14th November 2013

Re **Section 75W Application Clare Hotel and Administration Building
Central Park**

1 LEVEL 3
1:100

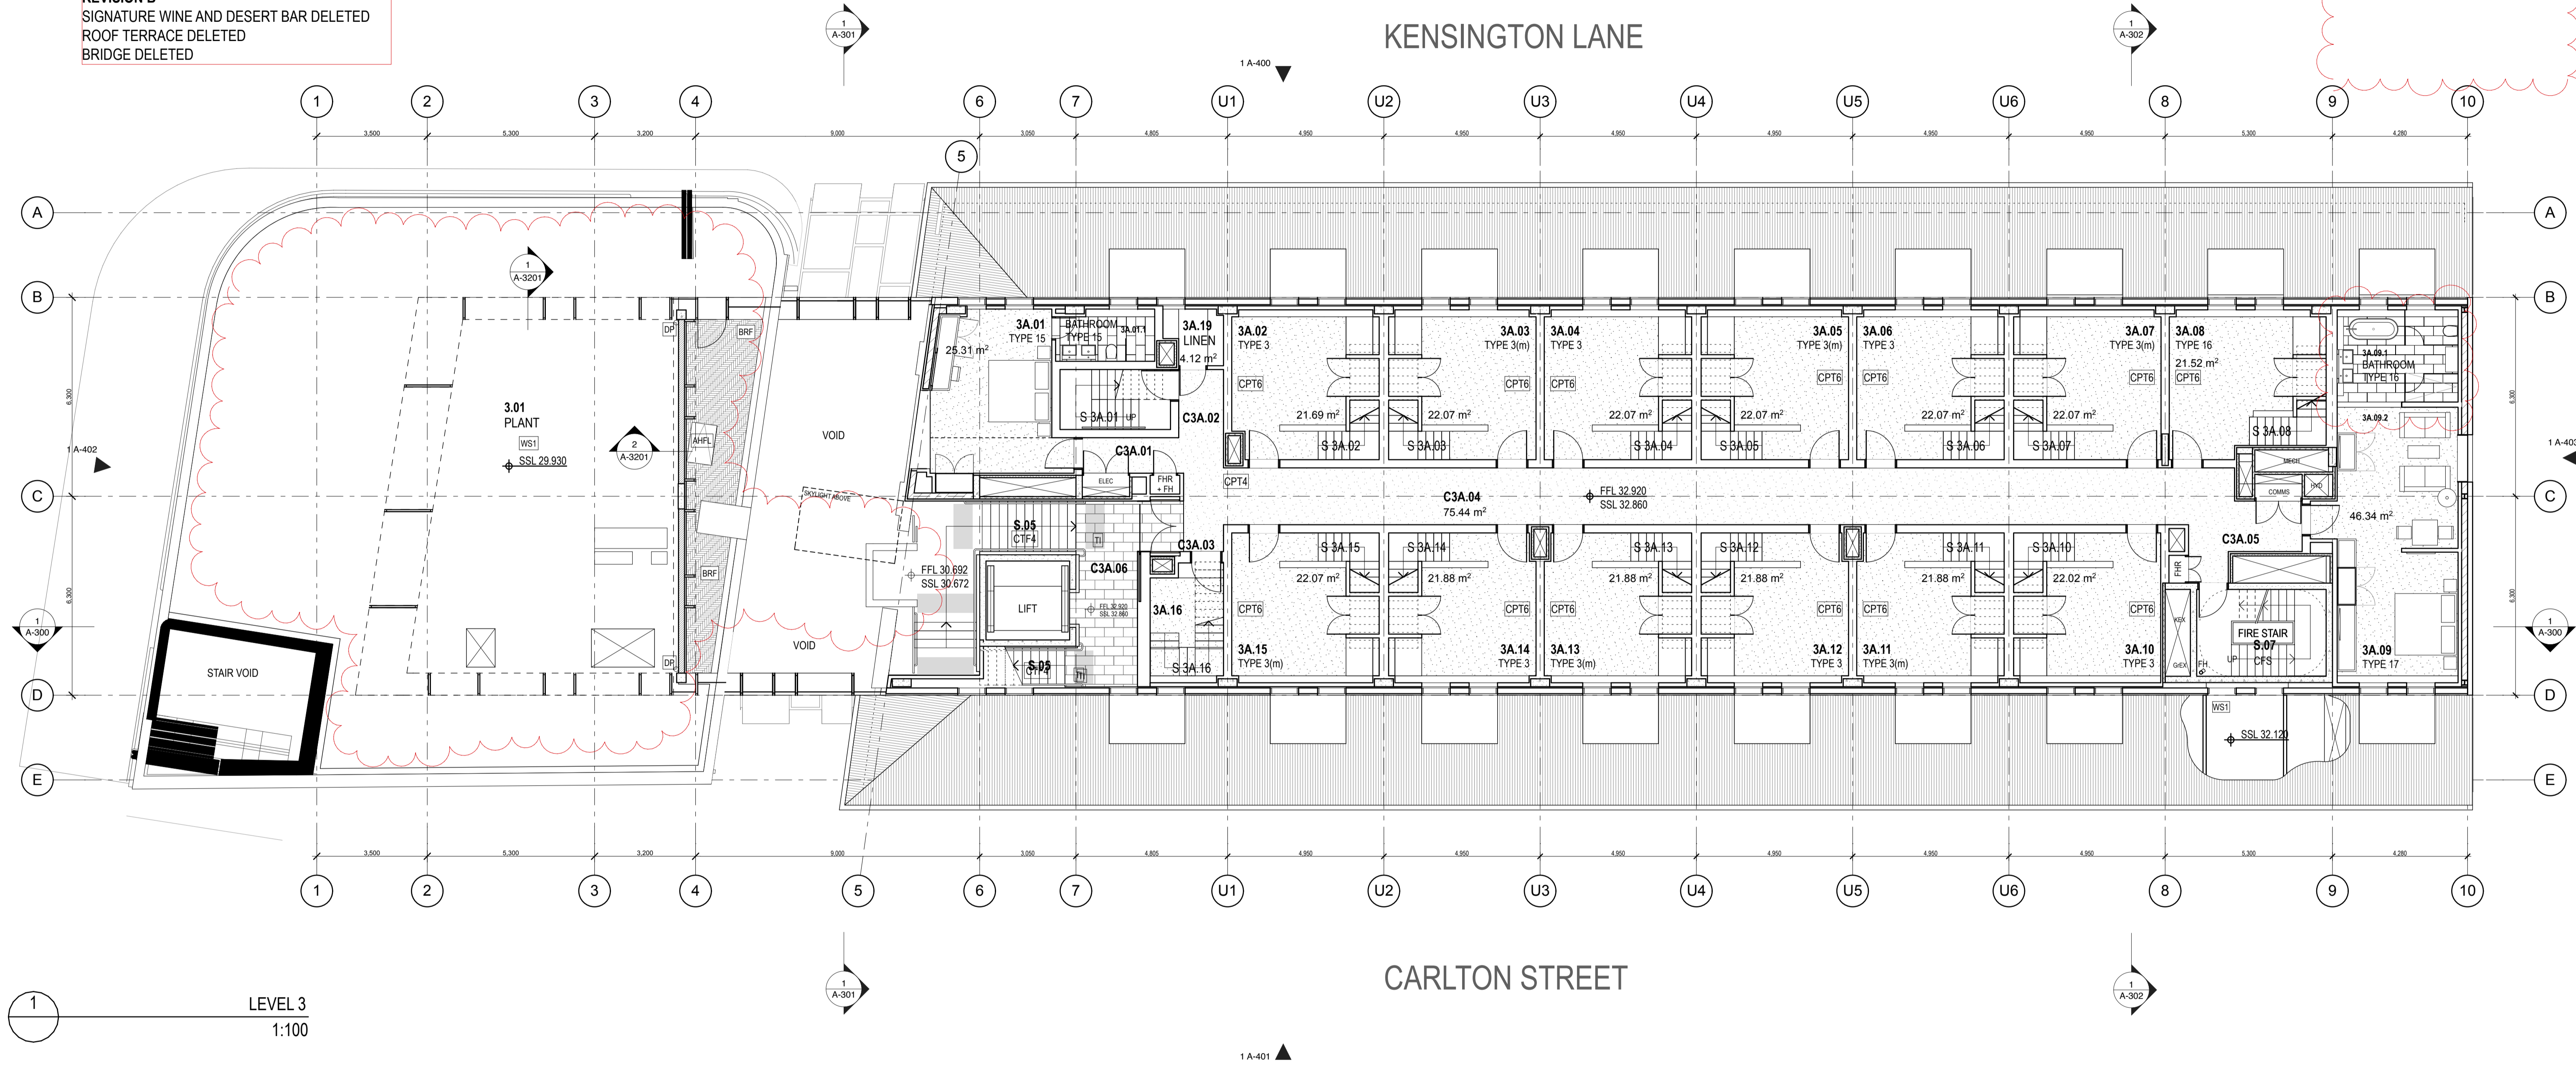
Hotel Clare: Removed proposed wine and dessert bar, area now use for plant, removed handrail around roof as now not accessible
Comment: This has no adverse heritage as the works were new, removal of the handrail has no adverse impact as it is a new element.

1 WEST ELEVATION
1:100

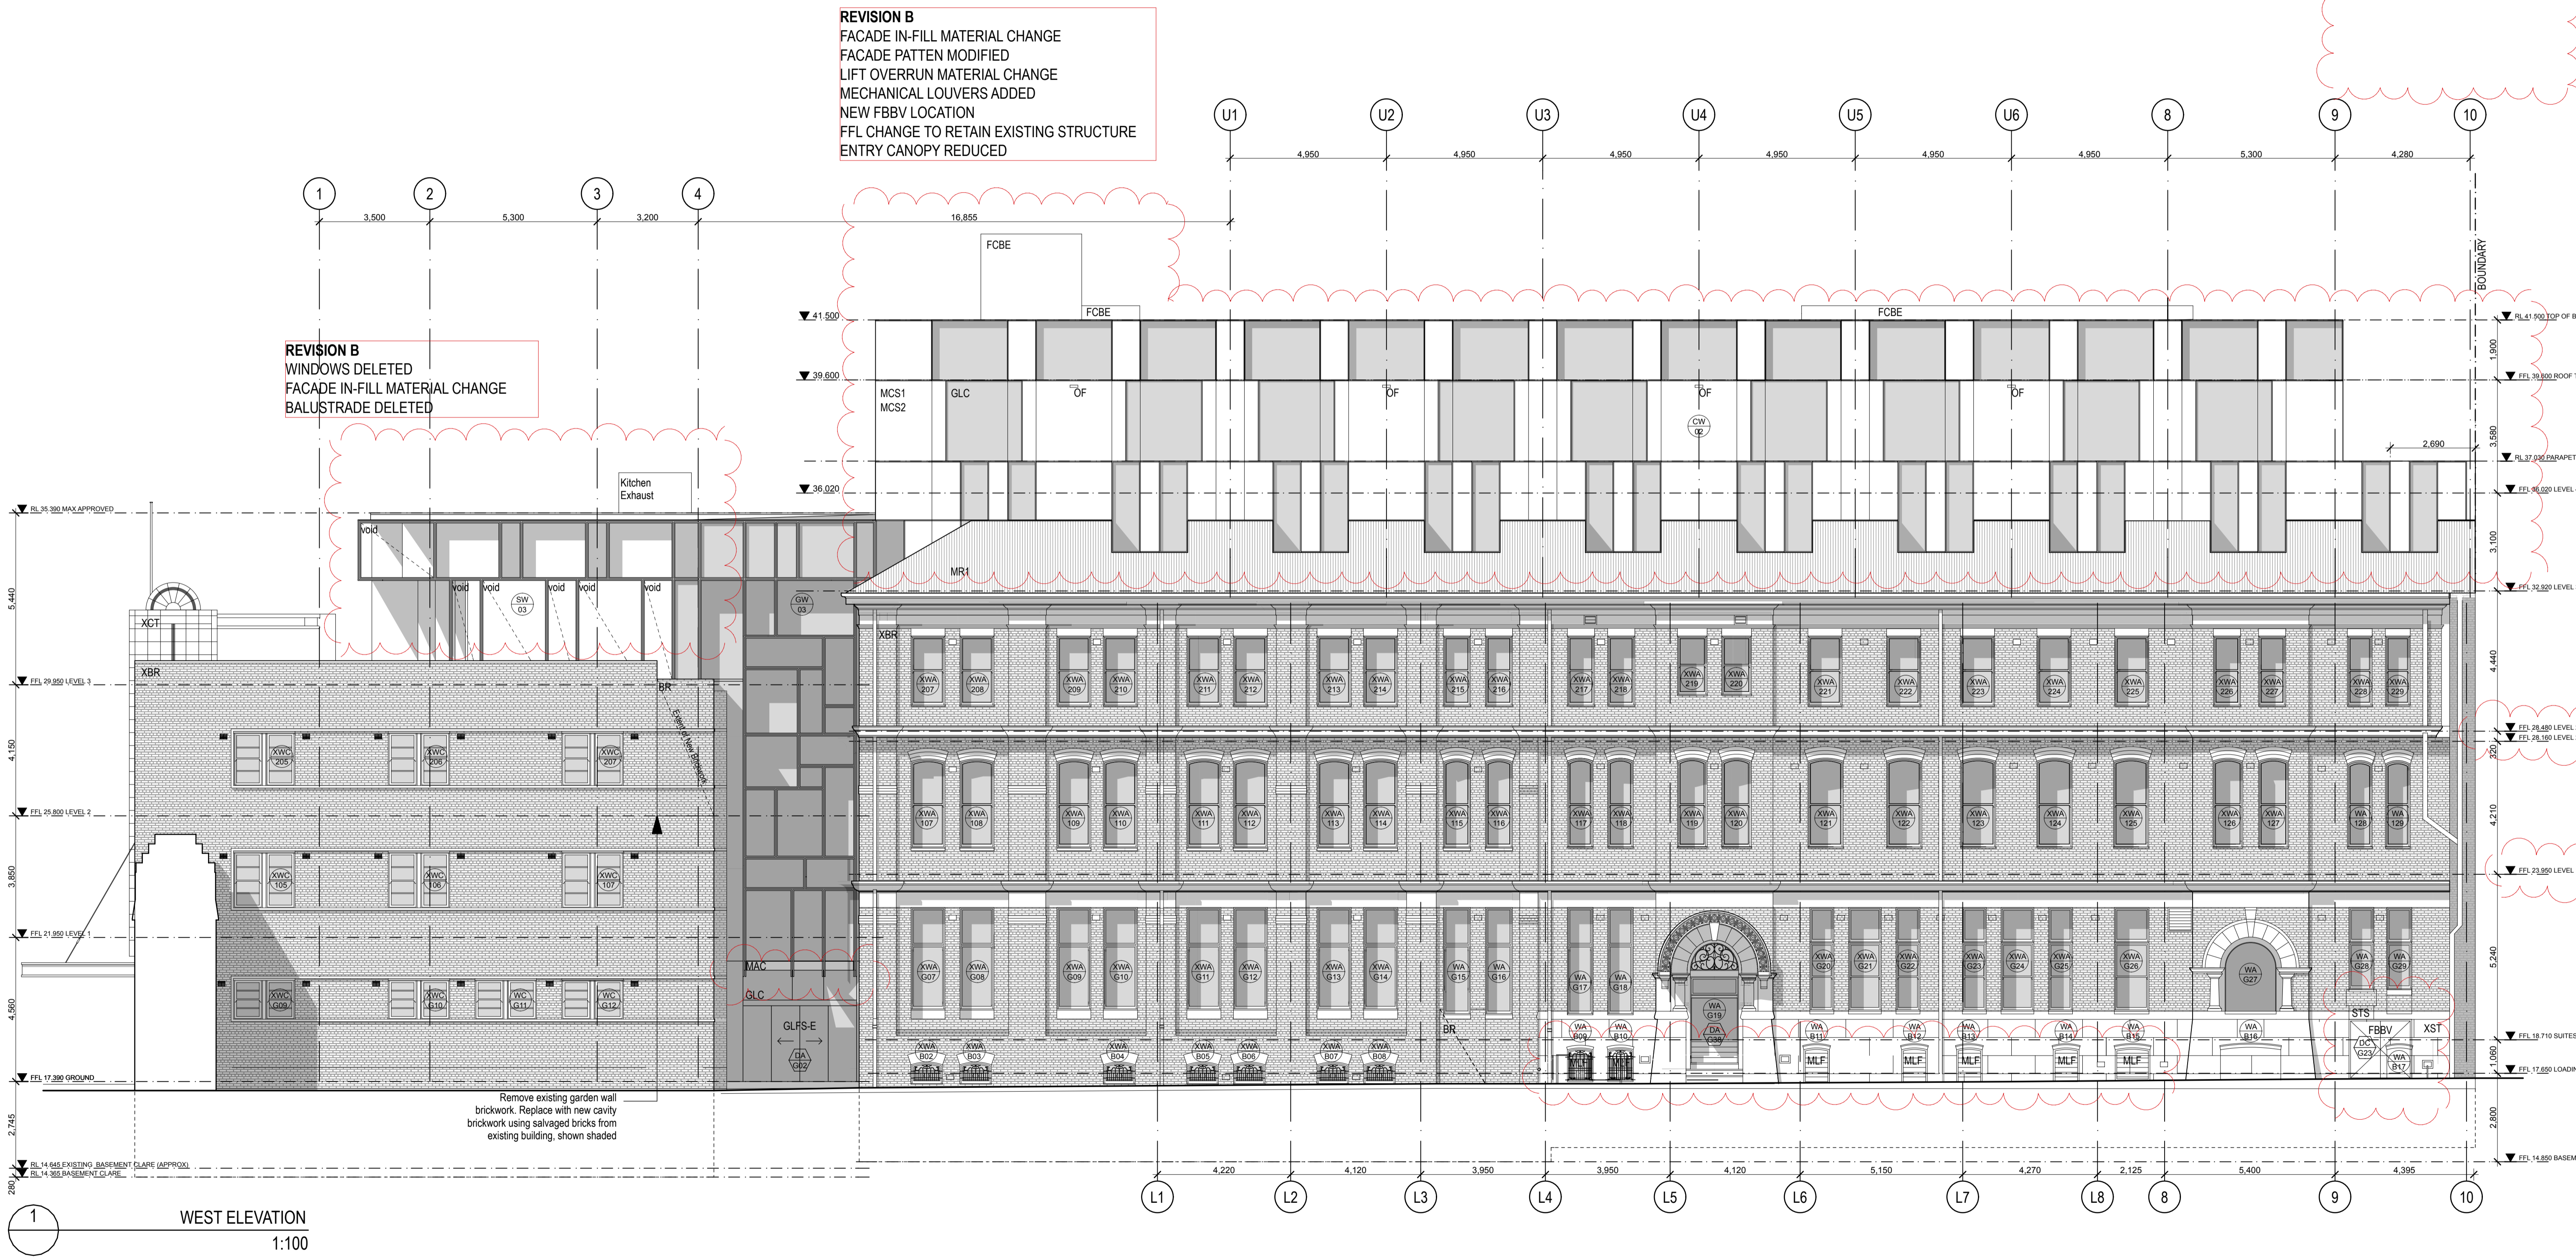
Hotel Clare: Changed door to window on Broadway elevation at ground floor
Comment: This has a positive heritage outcome as it reinstates a former window that was part of the original fabric.
